KITITAS COUNTY

MEMORANDUM

TO: Jeff Watson, Community Development Services
FROM: Christina Wollman, Planner II *CW*
DATE: February 15, 2011
SUBJECT: Schnebley BL-11-00005

The Public Works Department has reviewed the Request for Boundary Line Adjustment Application. In order to ensure that it meets current Kittitas County Road Standards, the applicant needs to provide the following prior to final approval:

Proposed 0.40 Acre Parcel

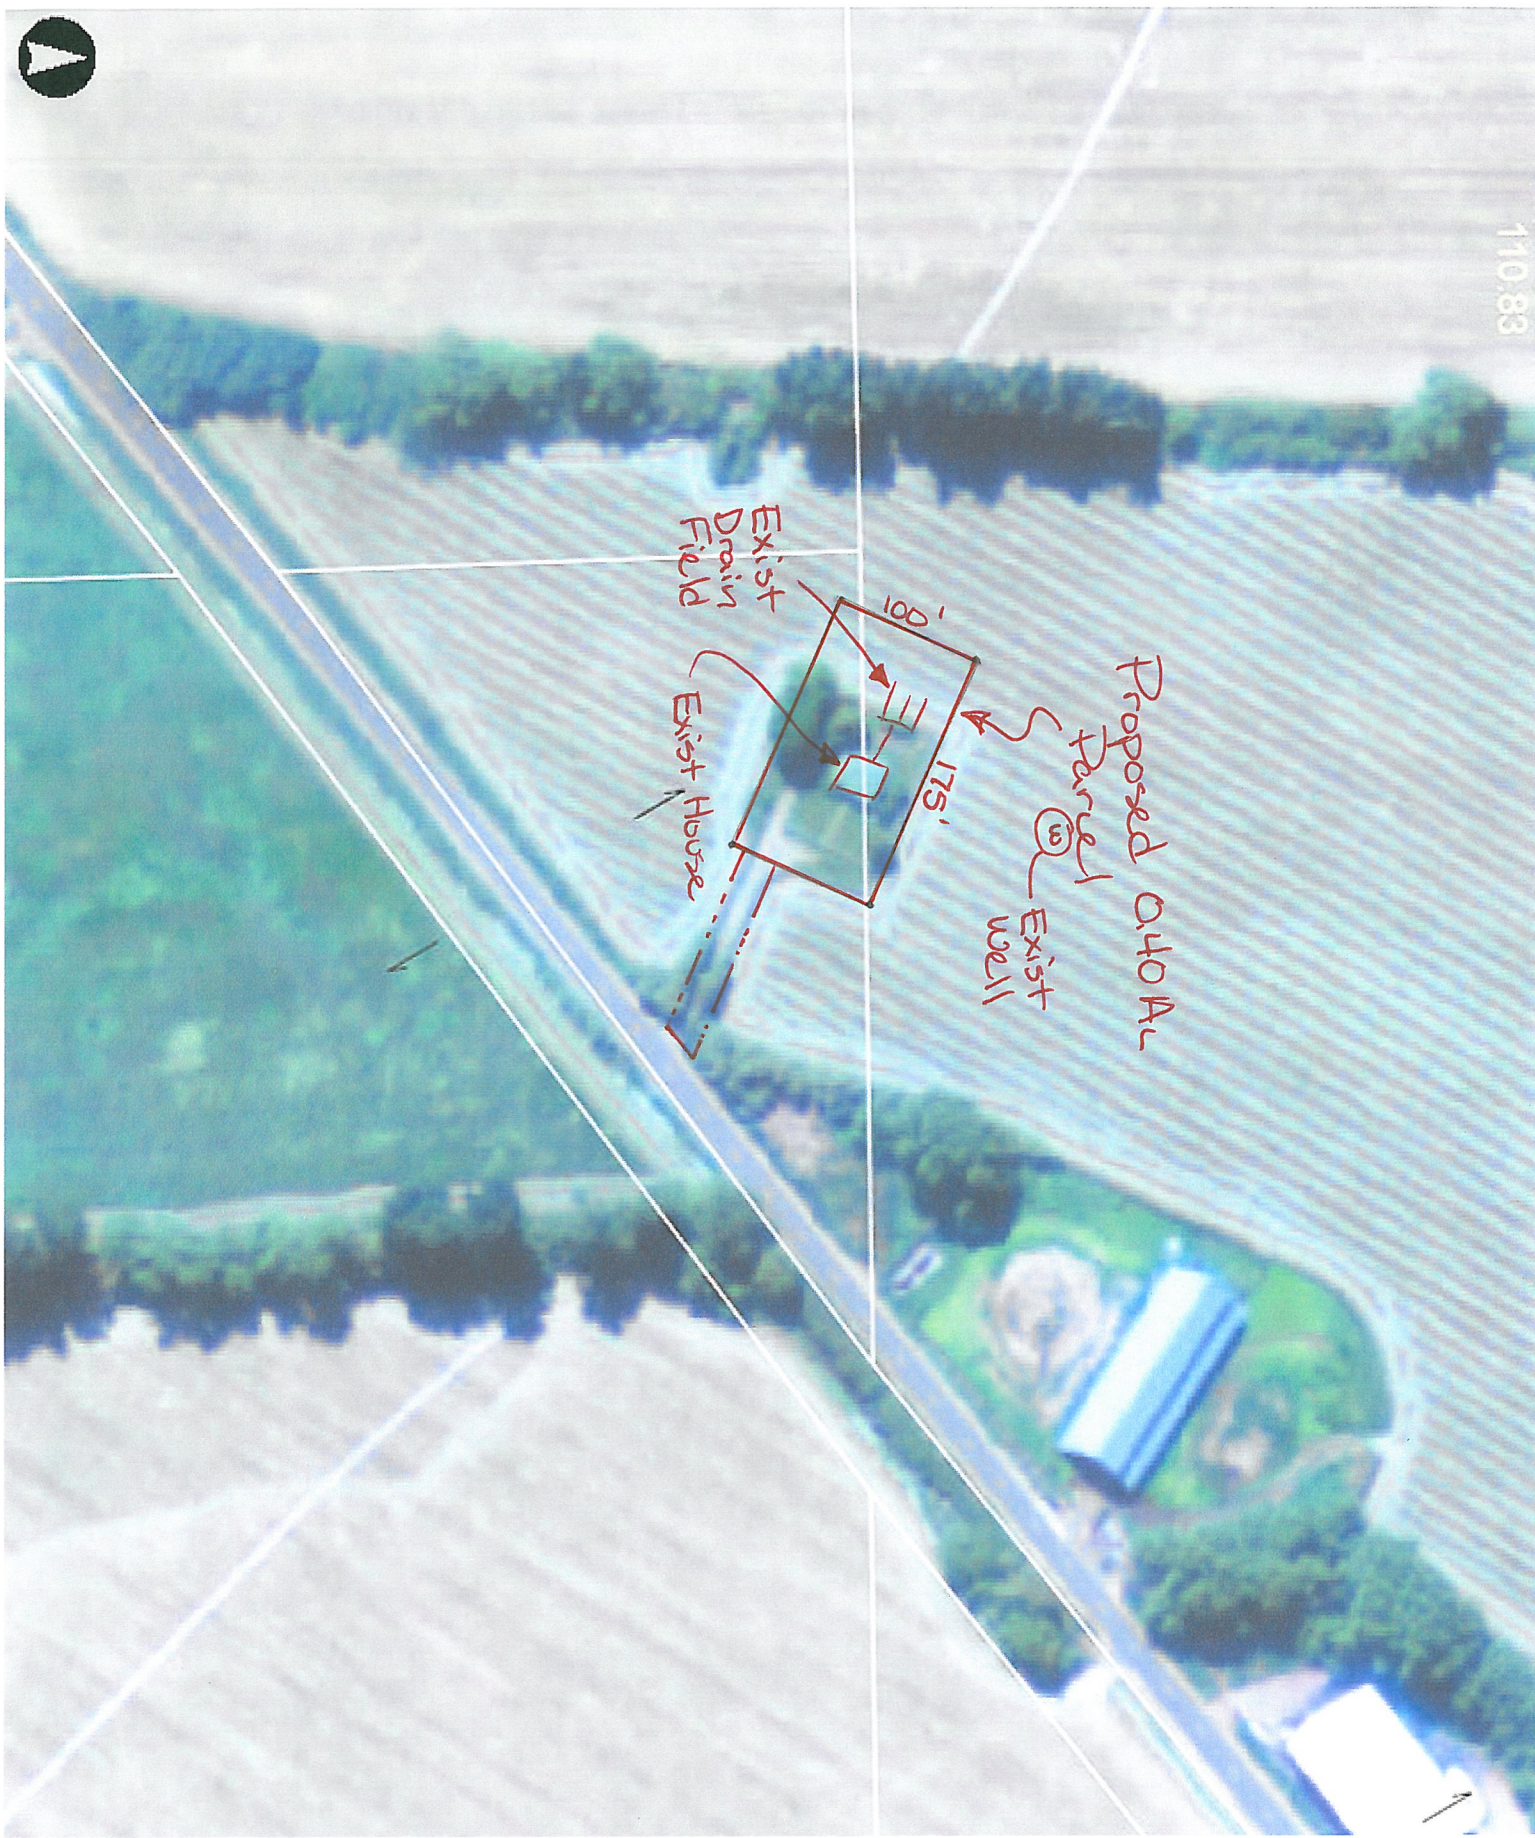
1. The proposed access with appropriate easement(s) shall be shown and shall conform to applicable Kittitas County Road Standards.
2. A revised legal description that describes the final configuration of the subject property shall be required.
